CITY OF ALBUQUERQUE

May 8, 2012

**Re: BJ Restaurant- Winrock Mall, Conceptual Grading and Drainage Plan
Engineer's Stamp Date 4-13-12 (J19-D058A)**

**BJS BUILDING PERMIT DRAINAGE PLAN**

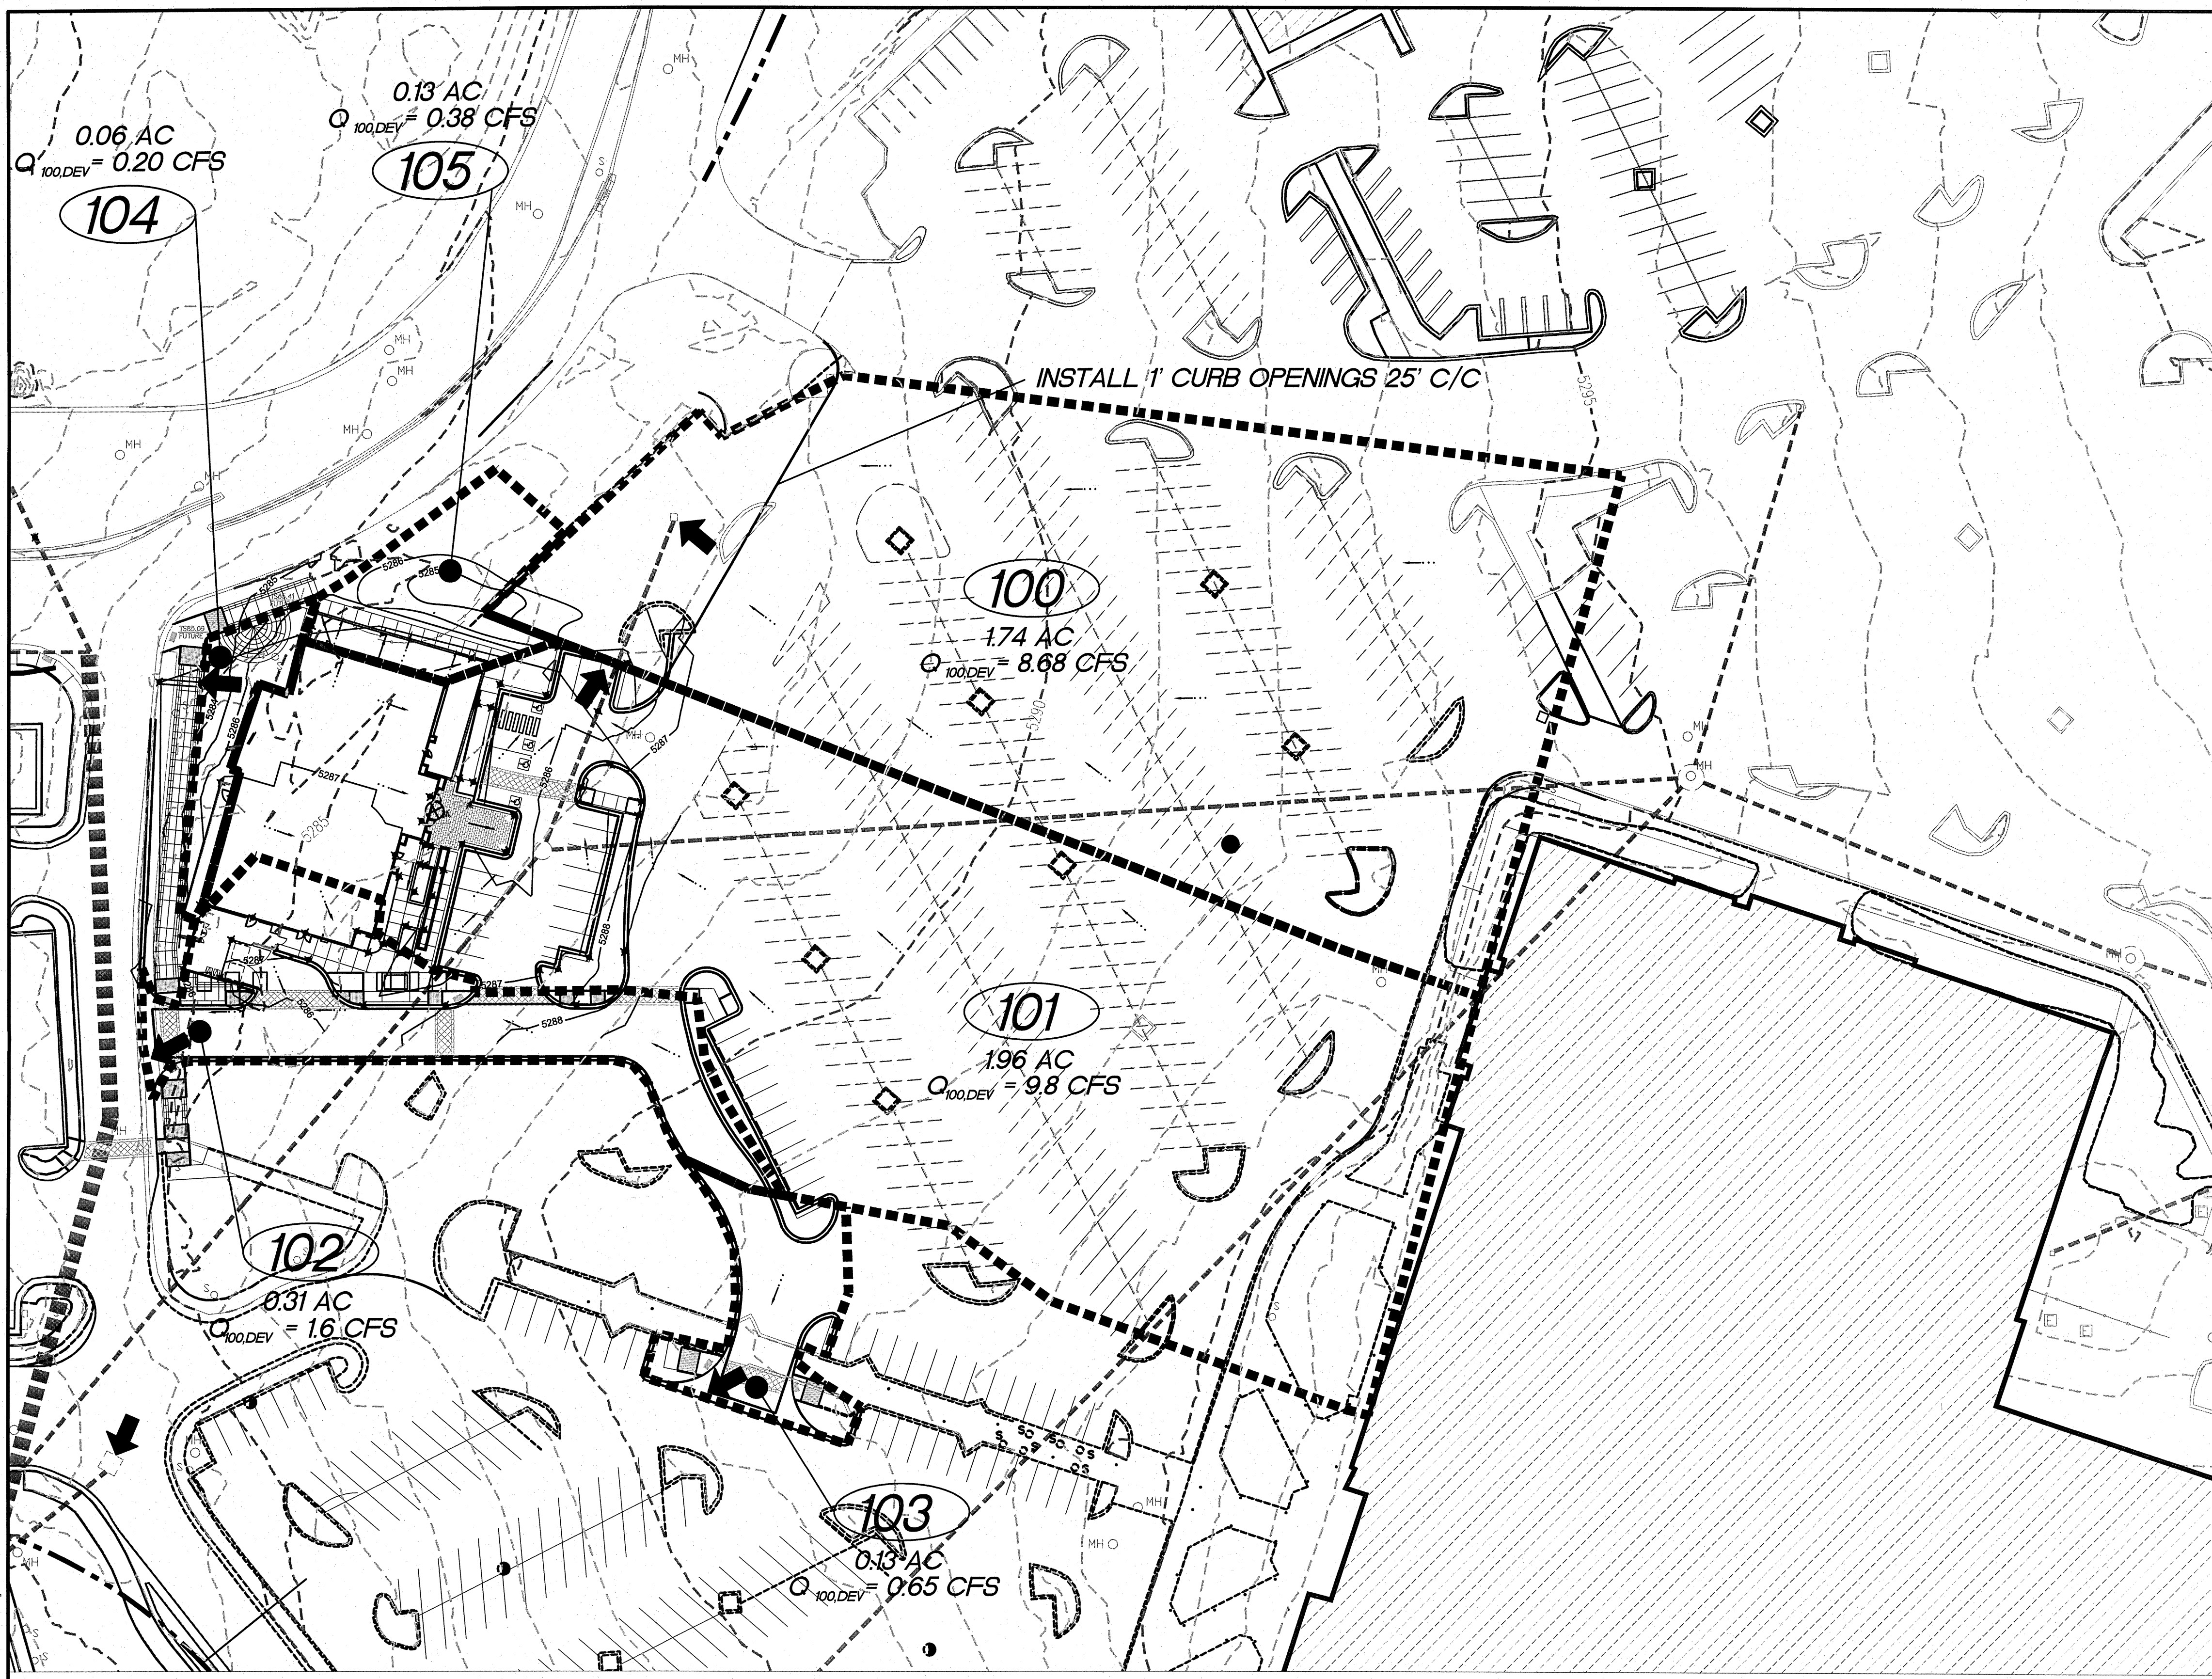
Hydrology provides the comment concerning the portion of the narrative that states "overflows shall by-pass the inlet and flow around the building in an earthen swale..." will be revised with the Building Permit submittal since an earthen swale is not shown on the plan.
